COUNTY OF HARNETT LAND USE APPLIC

PROPERTY LOCATION: SR #: 1141 SR Name: Buffalo Lake Rd. / Vick Keith Rd.  
Parcel: 03-9586-01-045B PIN: 9586-81-2175  
Zoning: RA20R Subdivision: Buffalo Lakes Lot #: 9 Lot Size: .40  
Flood Plain: X Panel: 150 Watershed: N/A Deed Book/Page: 1450/0188 Plat Book/Pages: Map 1

Sg. Family Dwelling (Size 36 x 40) # of Bedrooms 3 Basement N/A Garage N/A Deck 12x22 wood  
 Multi-Family Dwelling No. Units \_\_\_\_\_ No. Bedrooms/Unit \_\_\_\_\_  
 Manufactured Home (Size \_\_\_ x \_\_\_) # of Bedrooms \_\_\_\_\_ Garage \_\_\_\_\_ Deck \_\_\_\_\_  
Comments: included in total size

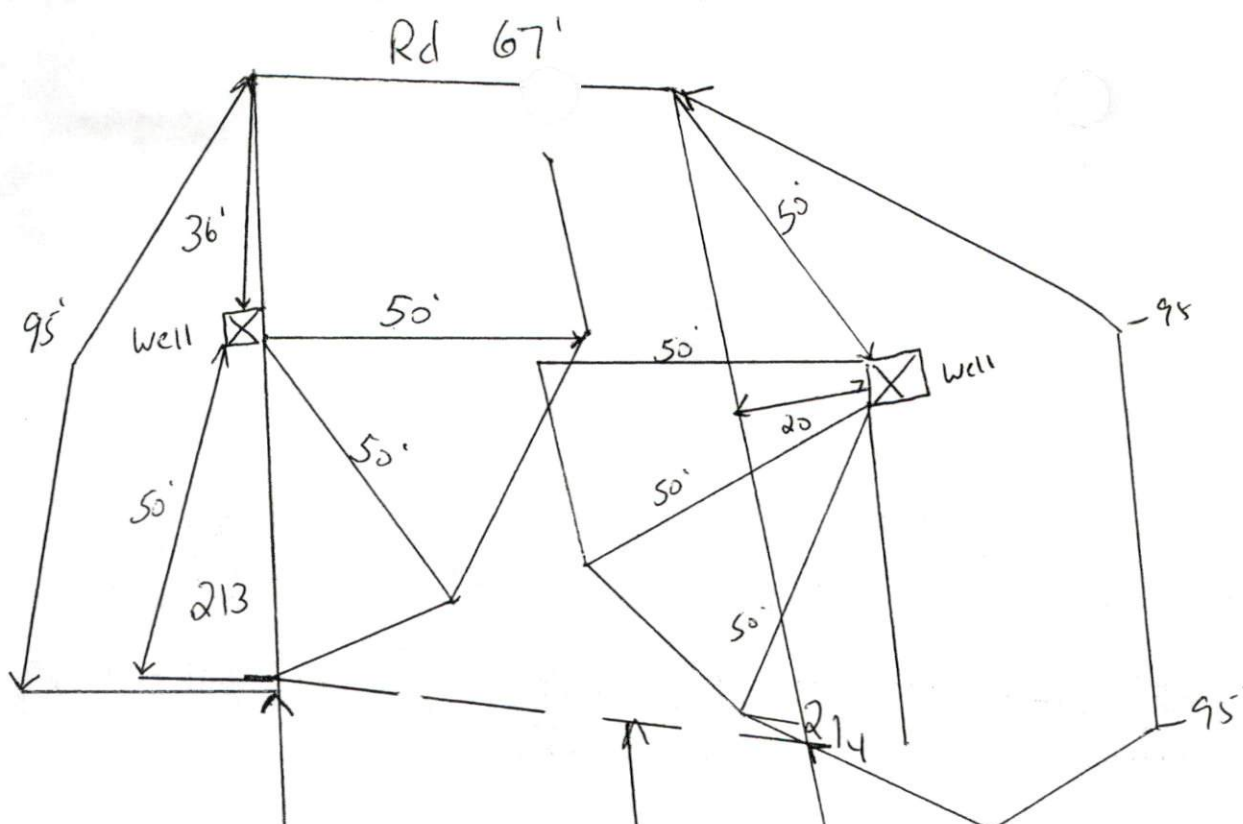
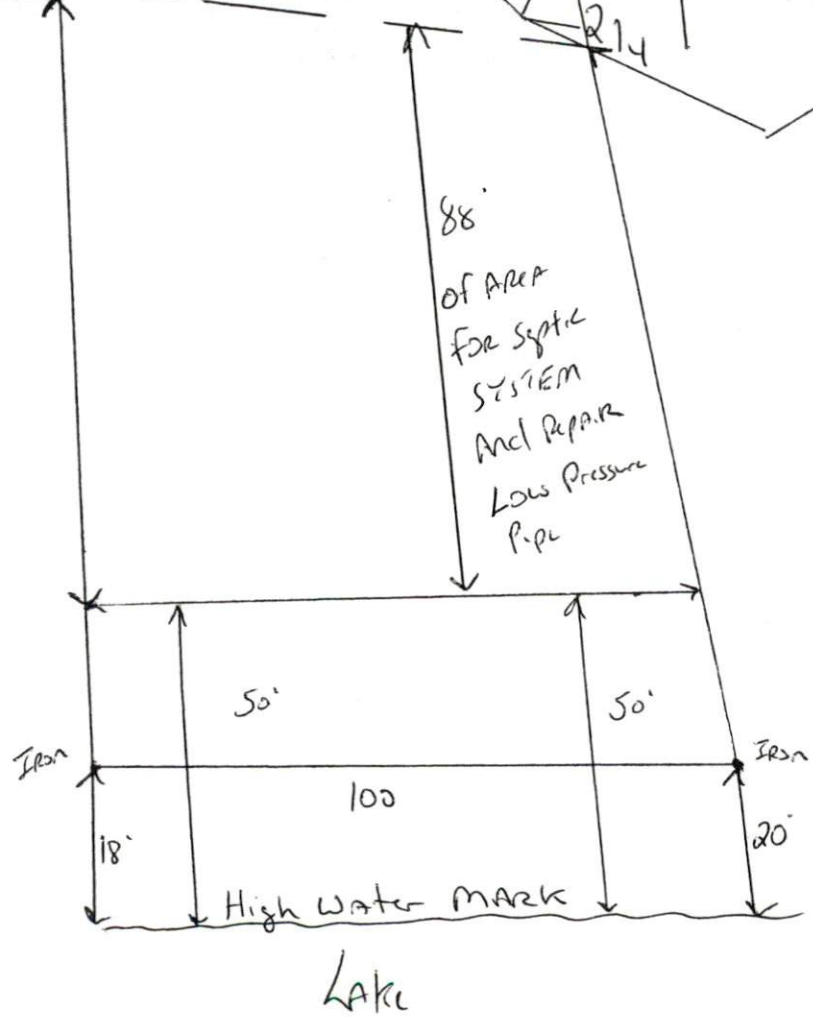
You will need to get someone to design low pressure pipe system & repair for this area and flag it out & then meet me on site for water

House would have to move forward to the very front of the lot The rear of the house could not be no more than 95' from front Property line
